35 Oakroyd Avenue
Potters Bar
EN6 2EL

May 2021

Re: 35 Oakroyd Avenue, EN6 2EL - Planning Application

Drawing PROPOSED Floor Plans

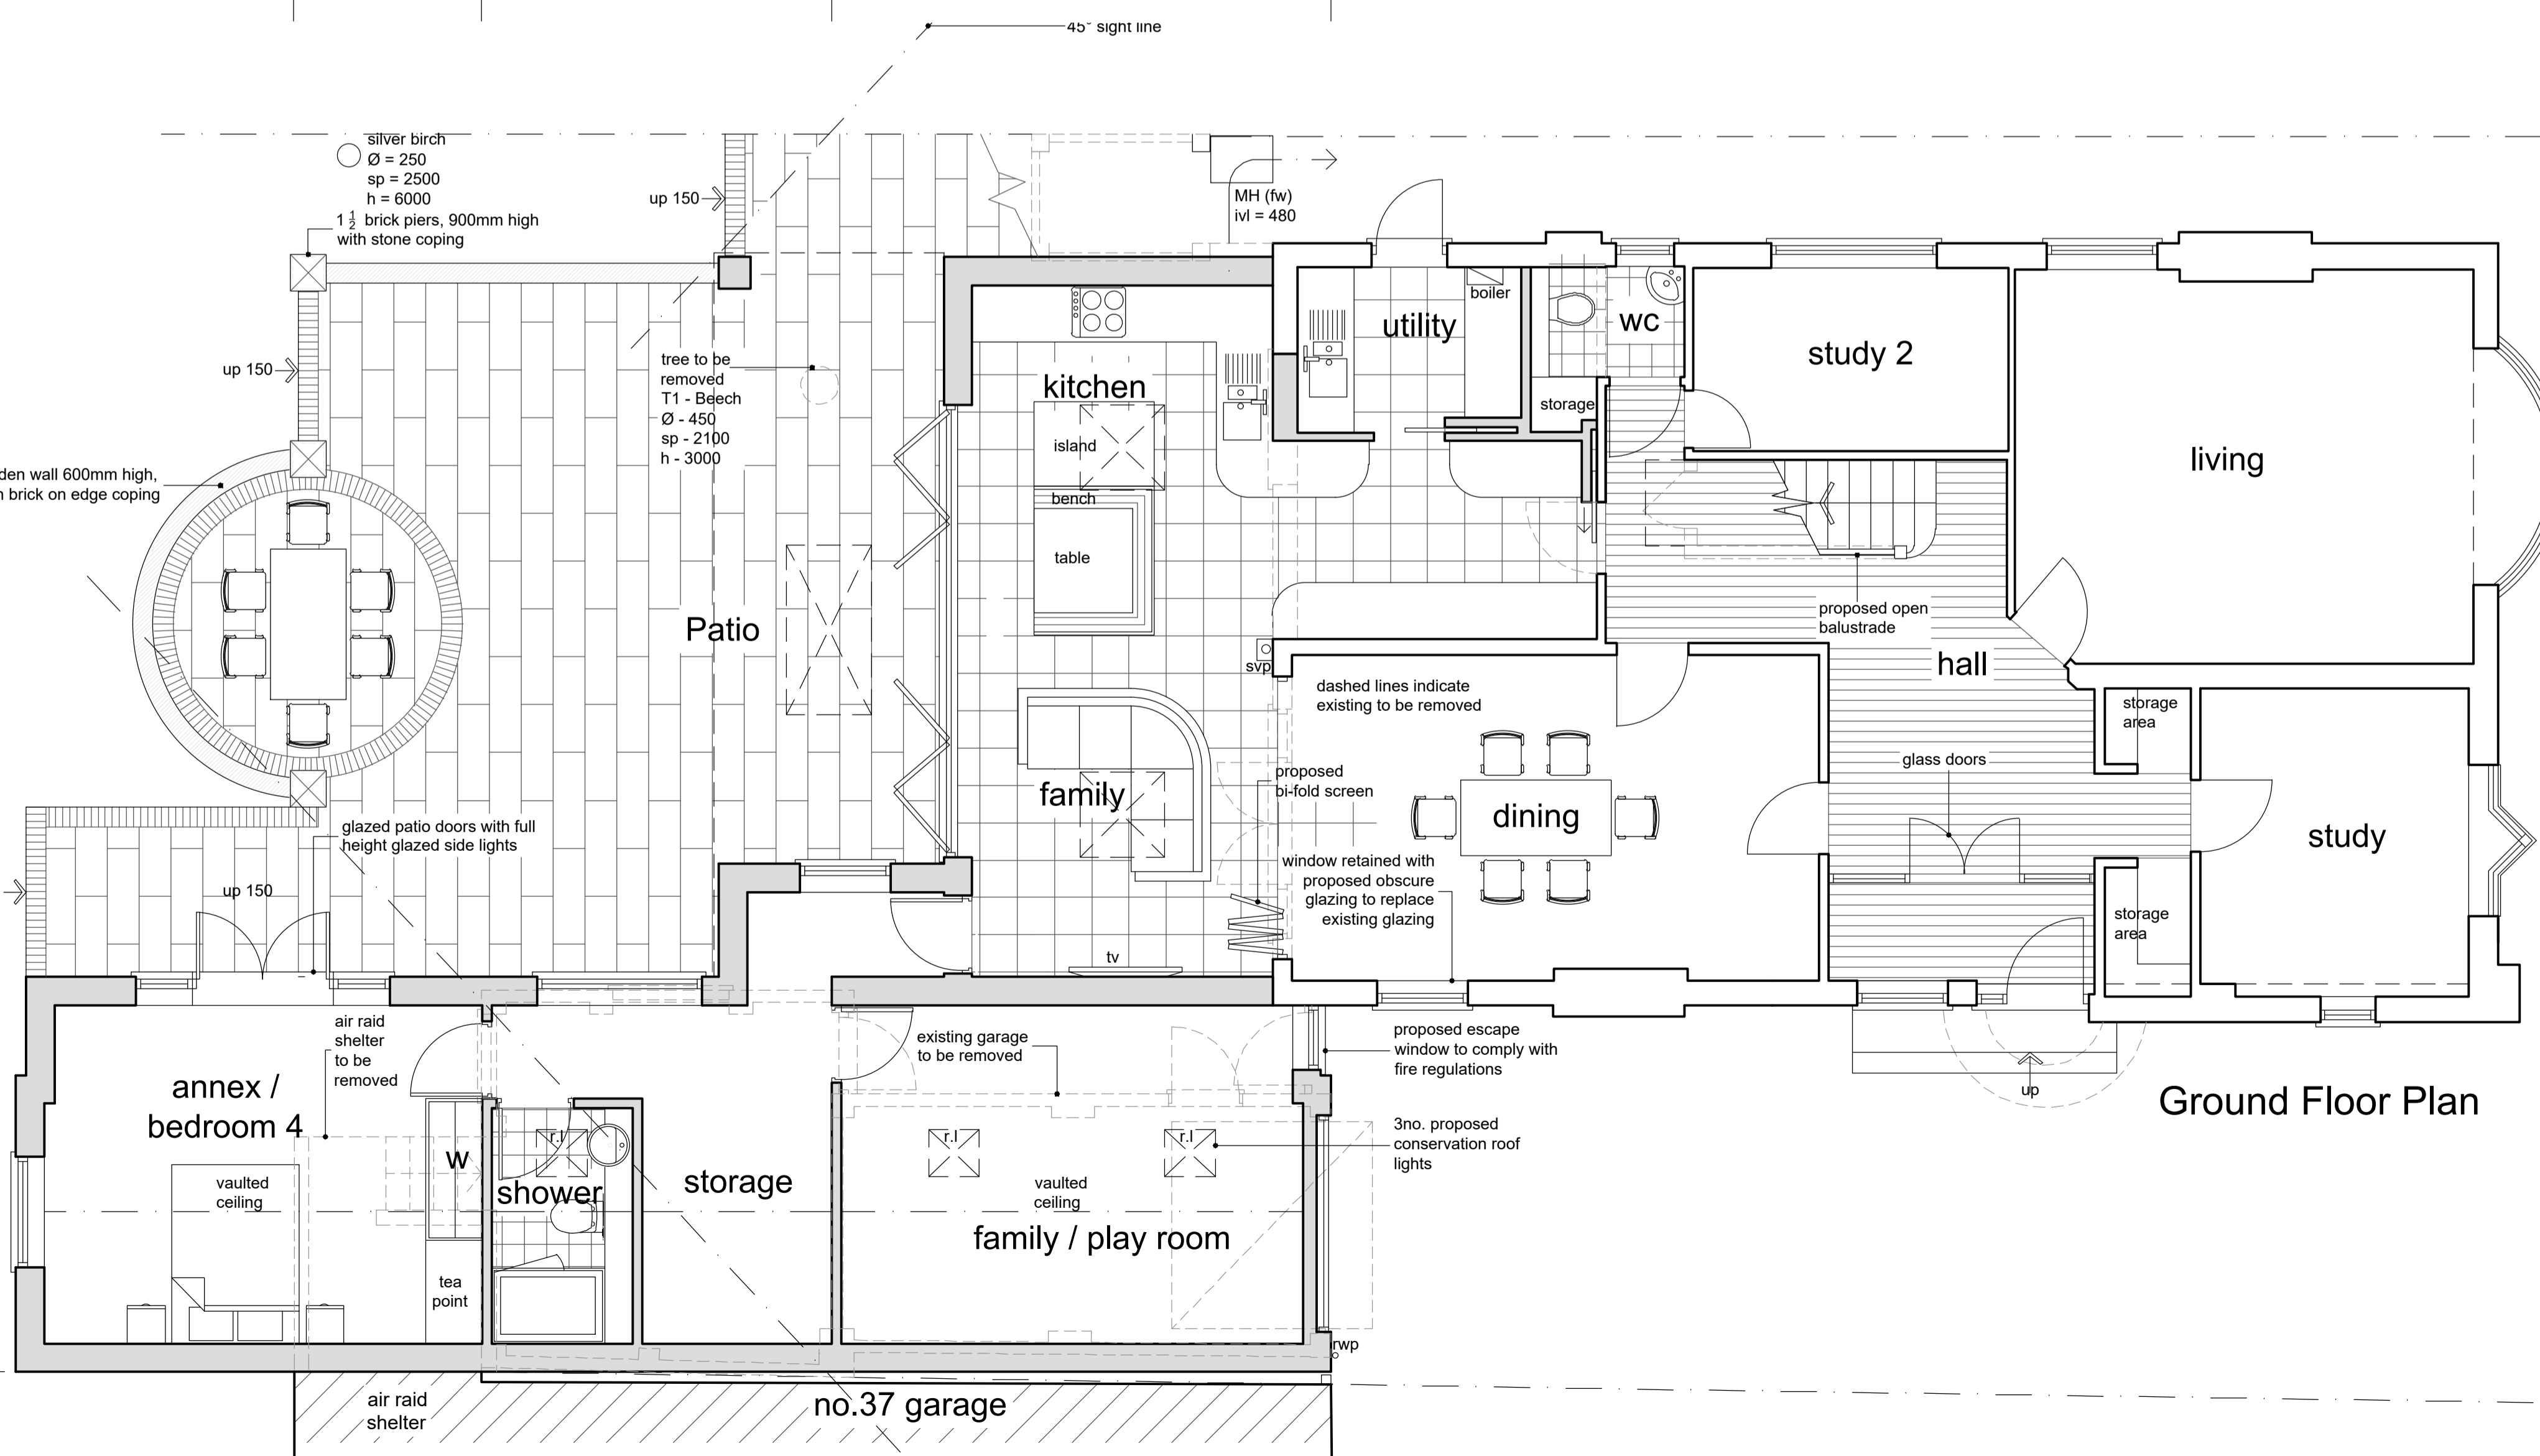
Enlargement of existing dormer window

As your records will show, our planning application number: 16/2135/HSE which was approved on 22 December 2016 (under current Conservation guidelines) included approval to enlarge a second dormer window to match the adjacent larger dormer. Despite that, the response from the Conservation Officer is that 'I would not support the enlargement of the existing dormer'.

Addition of new Larger Dormer to match existing

While the Conservation Officer states there is no principle objection to the proposed addition of a new third Dormer, he goes to recommend that 'the additional third dormer follows the same scale as the smaller dormer'. This does not appear to be consistent with the advice given with regard to plans for three new larger dormers to be added to the roof at 65 Oakroyd Avenue under ref: 20/0505/HSE, Date: 03/06/2020.

Position of proposed roof light

The Conservation Officer concedes that the insertion of one additional roof light does not raise an in-principle objection, but he then goes on to advise that 'the location of the proposed roof light is too close to the front of the property'. He recommends it is set well back (at least 5 metres) from the front gable. Unfortunately that is unworkable as doing that would locate the proposed roof light outside the ensuite bathroom for which it is intended to provide both natural light and ventilation.

- Change of rear extension from crown roof to flat roof with extension stepped in from the flank elevation.
- Move proposed single storey side extension backwards to maintain the existing garage line front.
- Change from flat roof on side extension to pitched roof to match existing.
